Subject: M 14-D8

Re: Waterman Inc. Grading and Drainage Plan

RE: WATERMAN INC. (M14-D8) RECEIVED JULY 19, 1984

RE: DRAINAGE PLAN FOR LANDS OF BROADWAY DEVELOPMENT COMPANY
(M-14/D8A) RECEIVED JULY 18, 1989

GRADING & DRAINAGE PLAN  
 WATERMAN, INC.

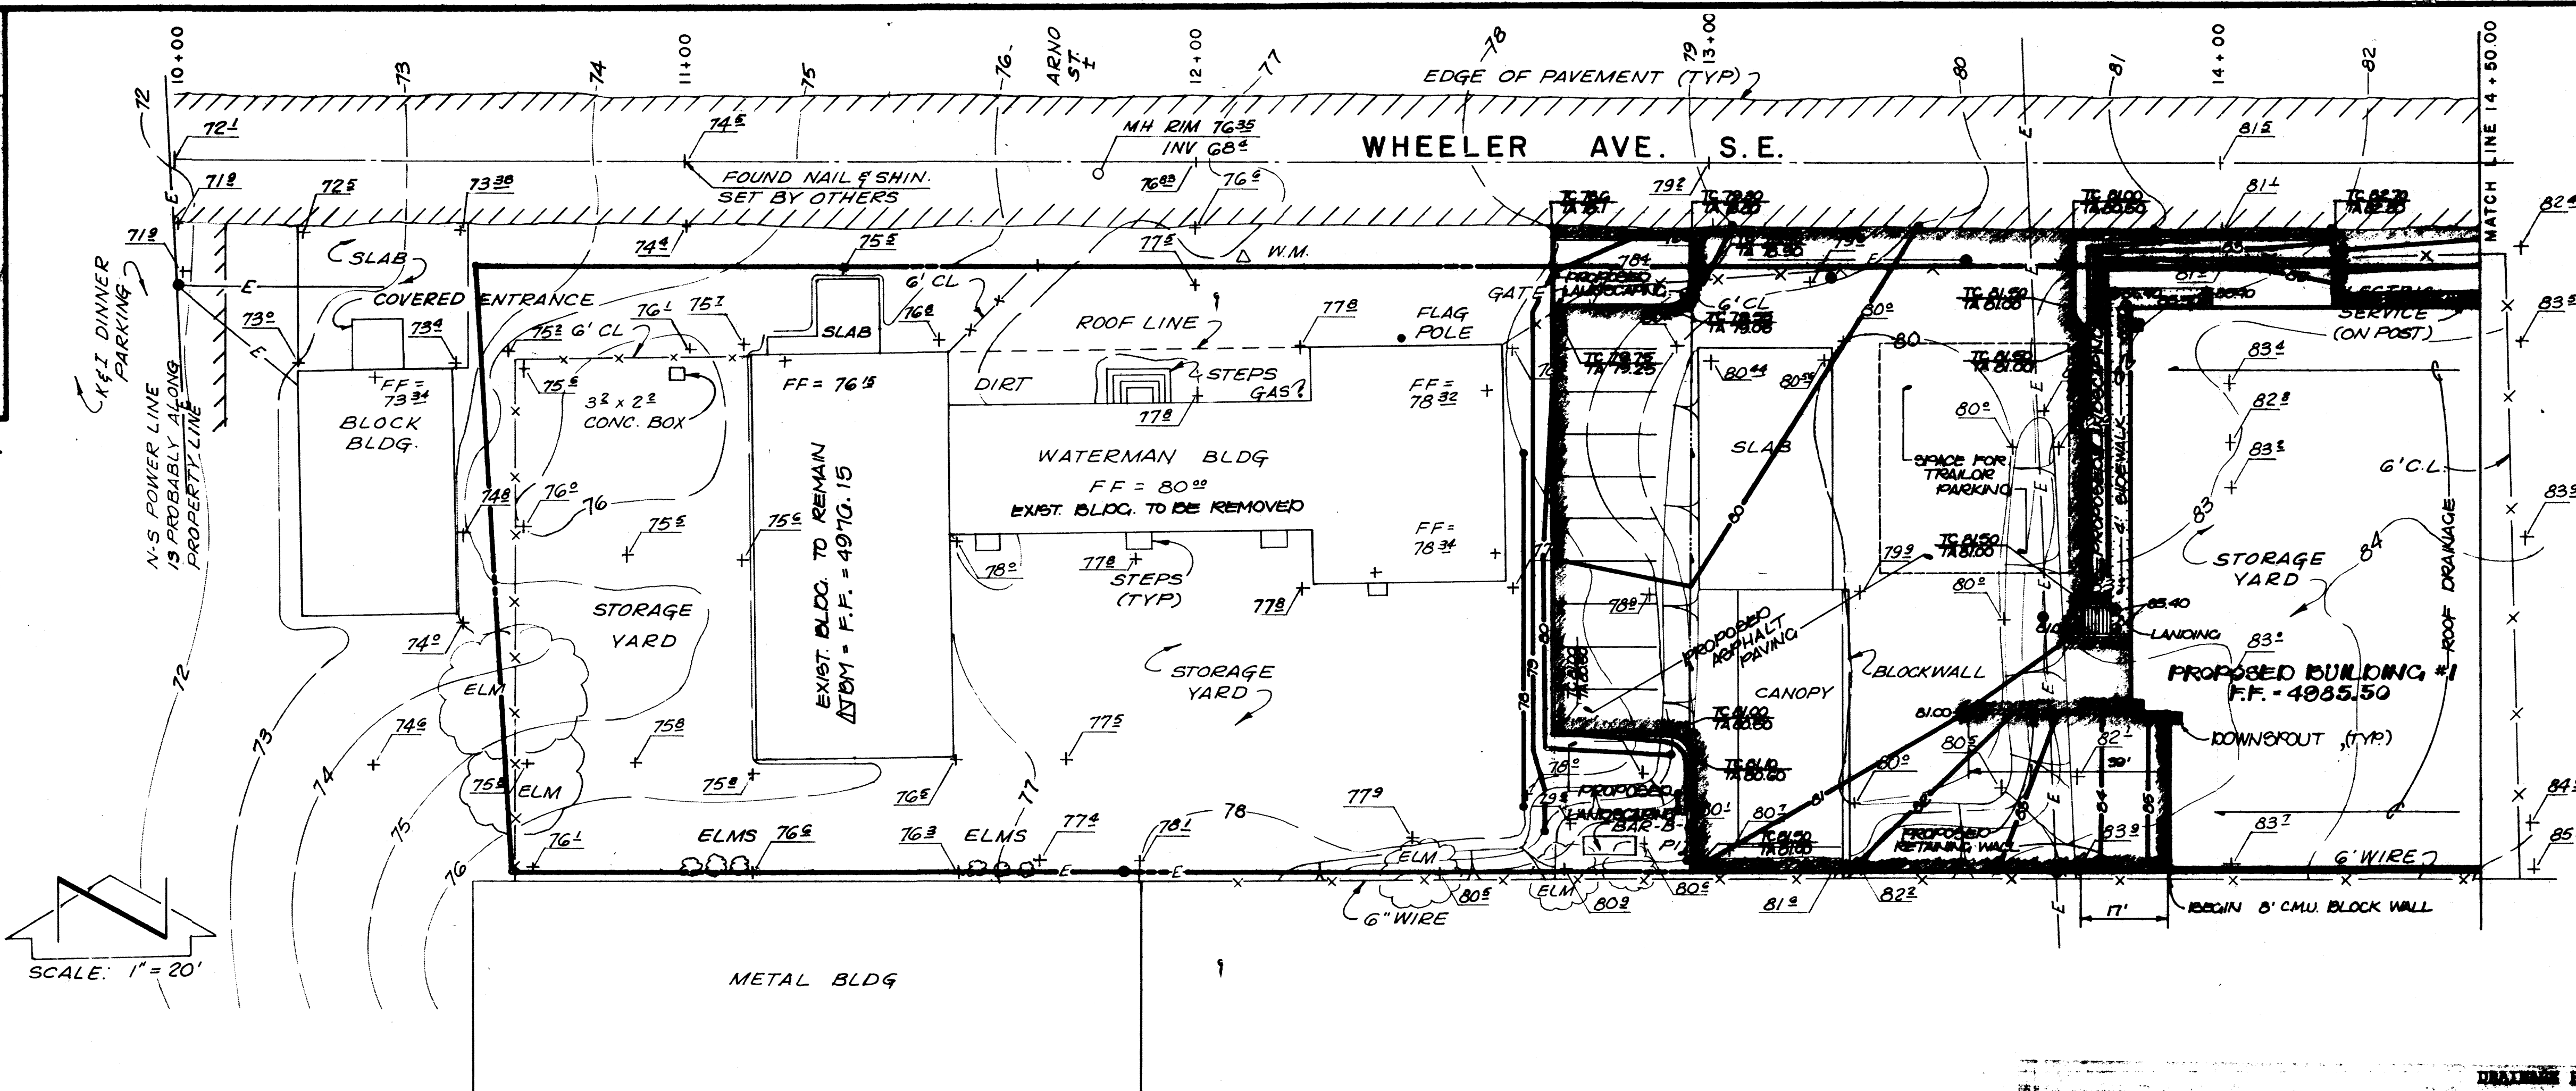
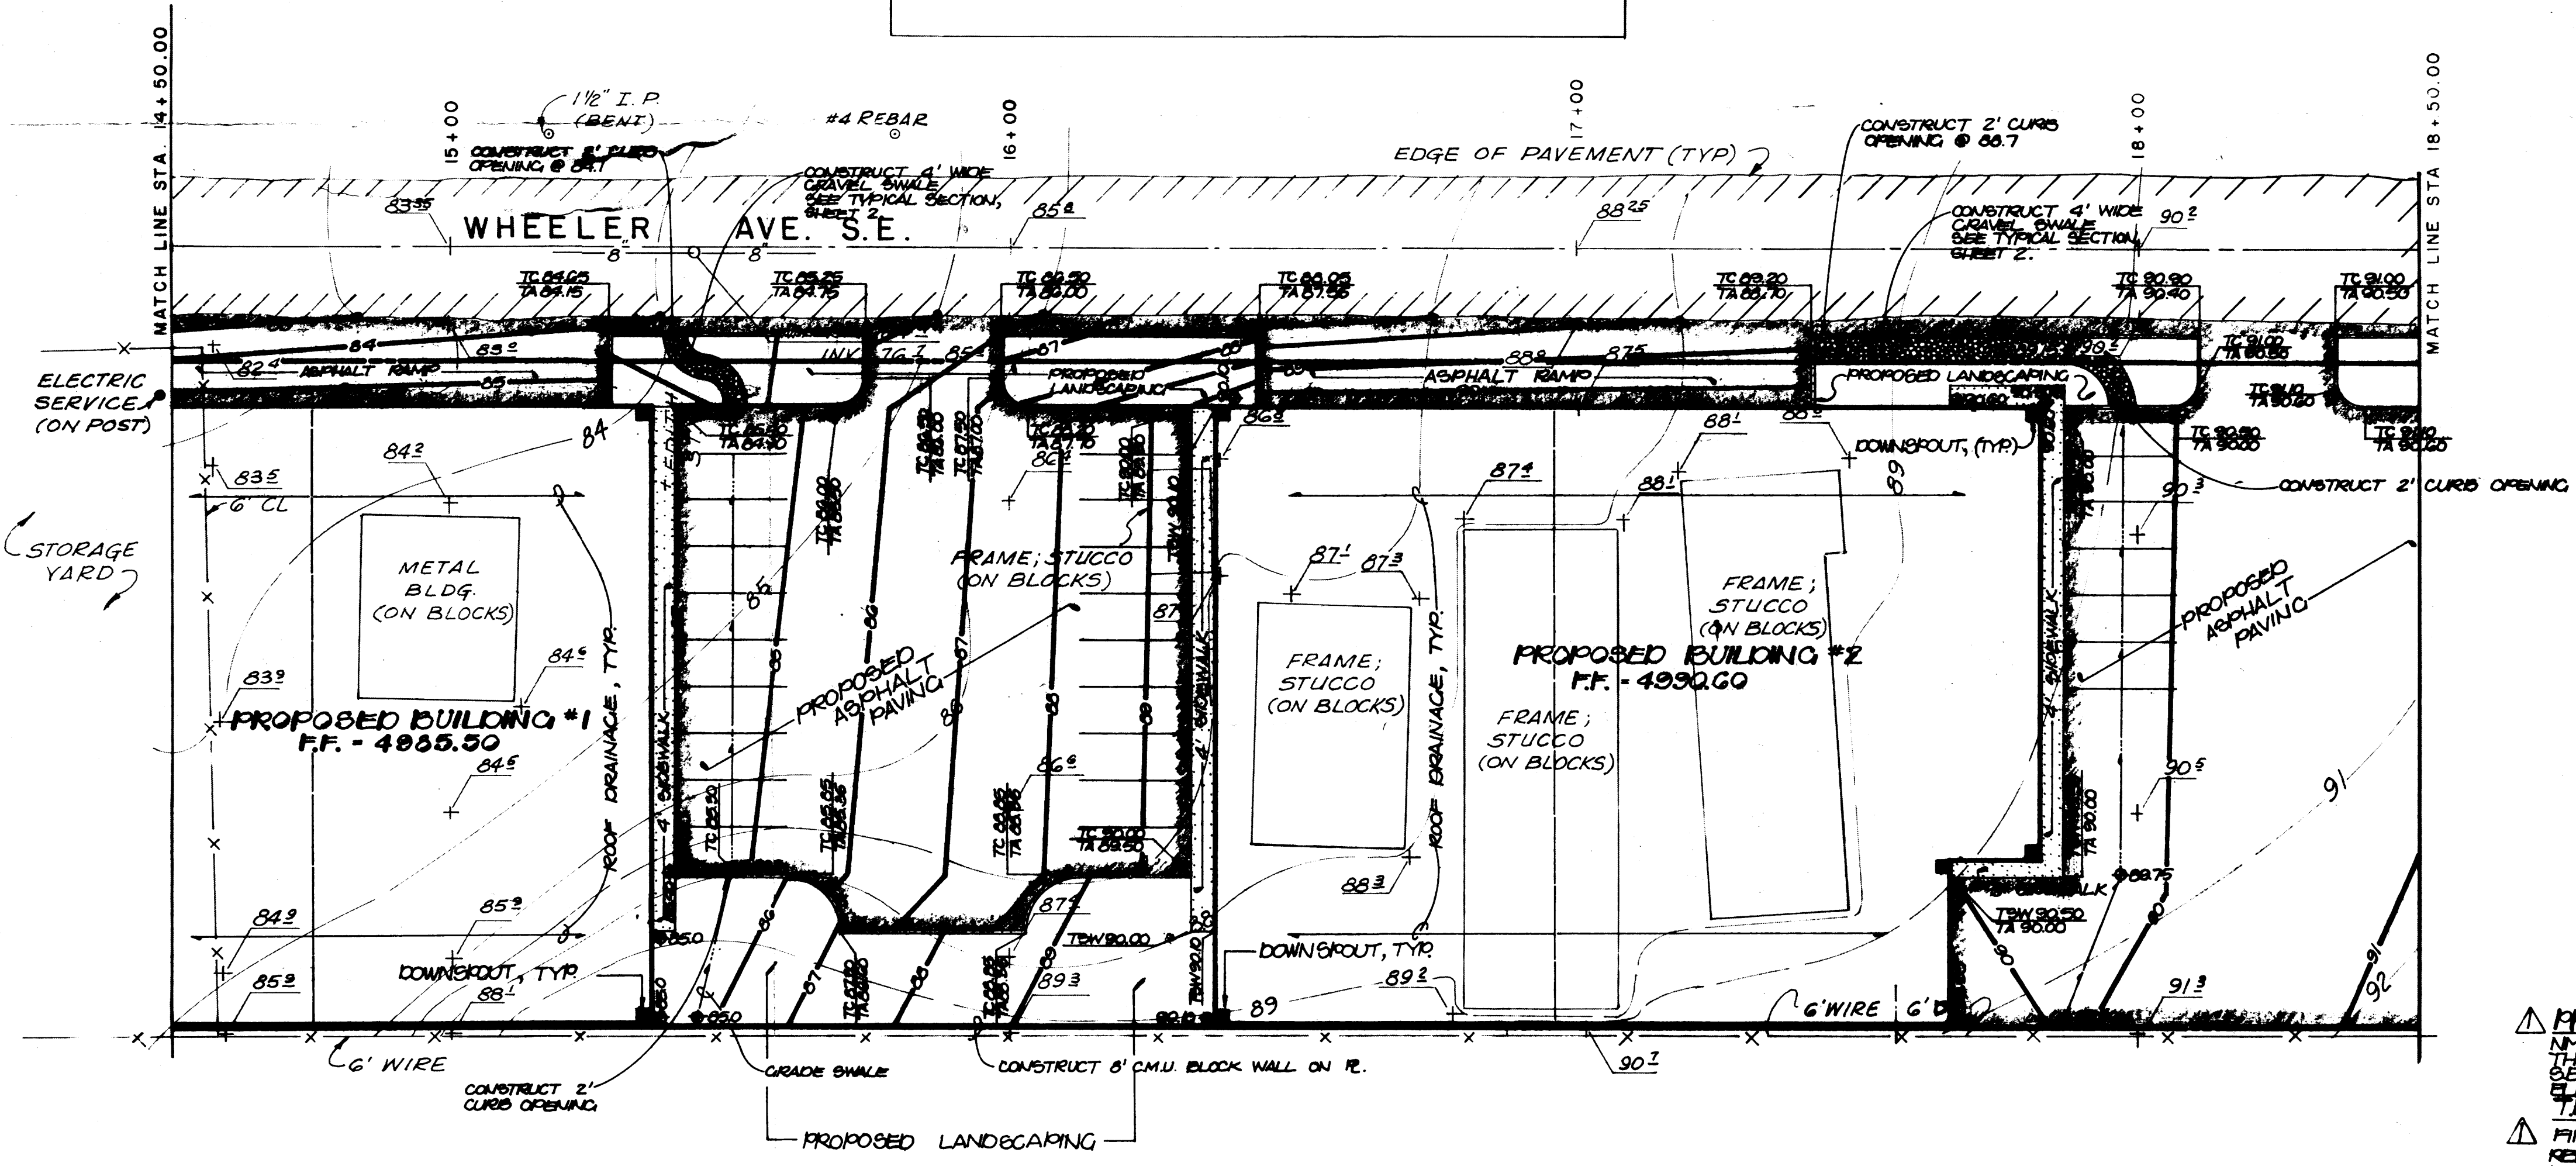
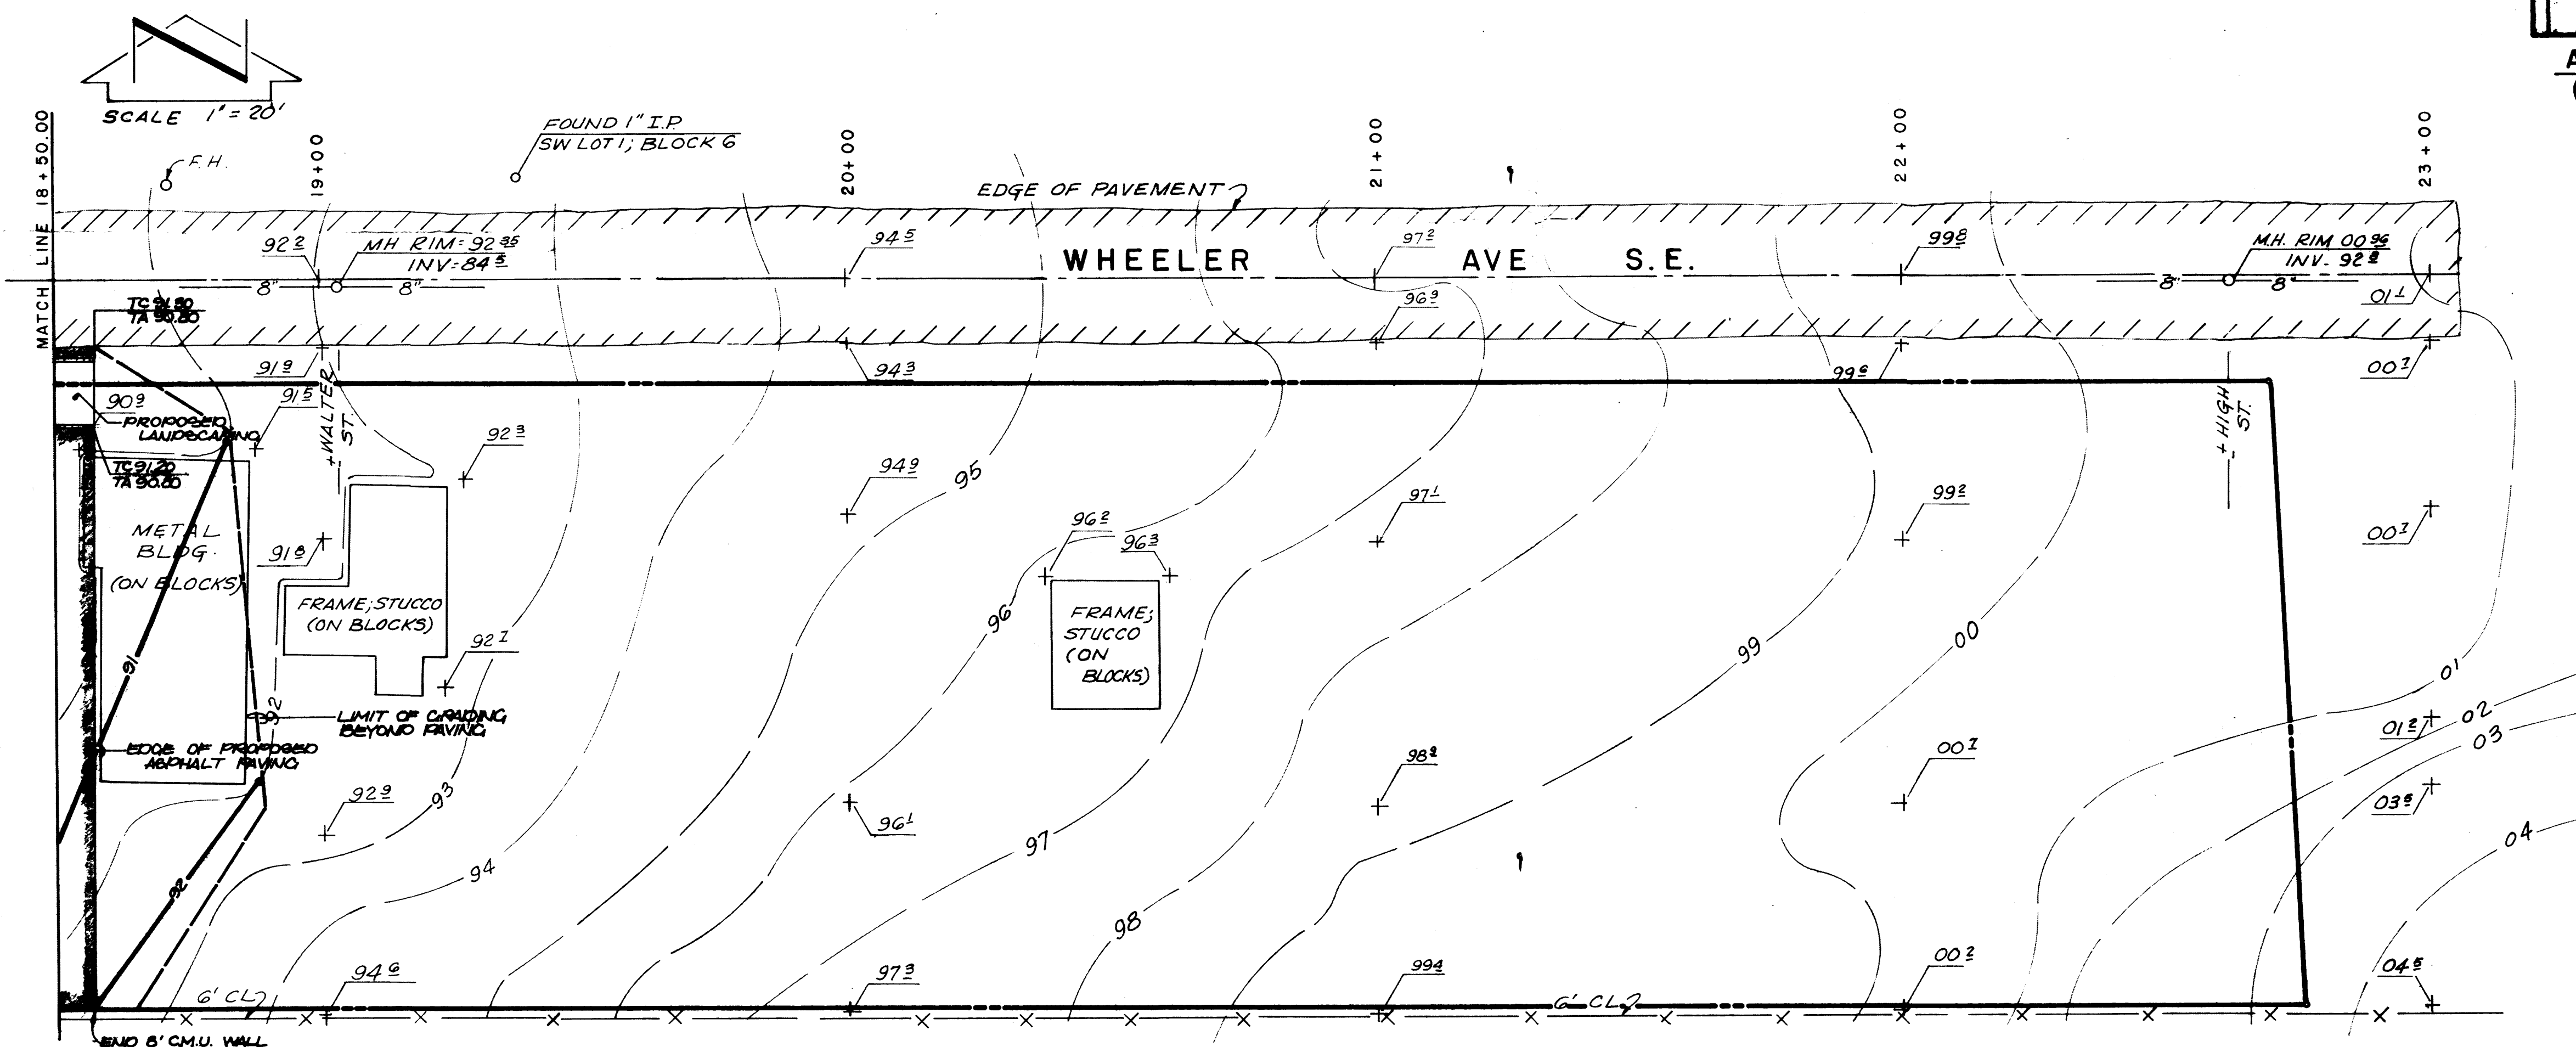
- ✓ 1. Information sheet designating resubmittal.
- ✓ 2. Professional's stamp and signature with resubmittal date.
- ✓ 3. Bench marks location, description and elevation of the:
 - A. Albuquerque Control Survey Vertical Datum
 - B. Temporary bench mark on-site
- ✓ 4. Please identify location of the downspouts.
- ✓ 5. What type of erosion control do you propose on the south portion adjacent to the asphalt paving between building 1 & 2 before roof runoff enters the paved area?
- ✓ 6. Will the project be built in phases? If so, a phasing plan will be required along with an erosion control plan for each phase.
7. Please provide a copy of document designating what portions of Wheeler have been vacated. (Otherwise approved street grades will be required along with the approved "Drainage Facilities Within City R/W" documents).

8. Private easements for the proposed drainage scheme across property lines will be required (an alternative to this easement would be to remove the common lot line between the lots by replatting).

1. Broadway S.E. drains to the south at the intersection with Wheeler.
2. There is a battery of existing catch basins on each side of Broadway just north of Wheeler which served to remove runoff from the street.
3. Broadway has an east to west cross slope such that runoff discharged from Wheeler to Broadway will cross Broadway to the west then drain in a southerly direction.
4. There is an existing water block in Broadway between Wheeler and Gibson such that the contributing basin which contributes overland flow to Broadway at the intersection with Wheeler is small.
5. That runoff which flows in Broadway south from Wheeler drains partly to San Jose and partly to Bethel. Each of these streets have storm drain systems which collect the runoff in the street. These streets also have curb and gutter on each side and are fully improved.

The information presented above addresses your comments concerning the subject project. Hopefully this will provide you with sufficient information to release the building permit. If street grades do become an issue, they can be made a condition for occupancy. Lastly, we are about to undertake a plat which will show that portion of Wheeler Avenue S.E. vacated by the DRB as well as eliminate further lot lines in this area. As I have stated before, Mr. Waterman acquired quite a few parcels of land in this area which he will plan to develop at a later date. Street grades, if necessary, would be more appropriate in conjunction with that future development than now because the platting would exist by which a cul-de-sac could be built at the east end of Wheeler which is the west property line of Mr. Waterman's property.
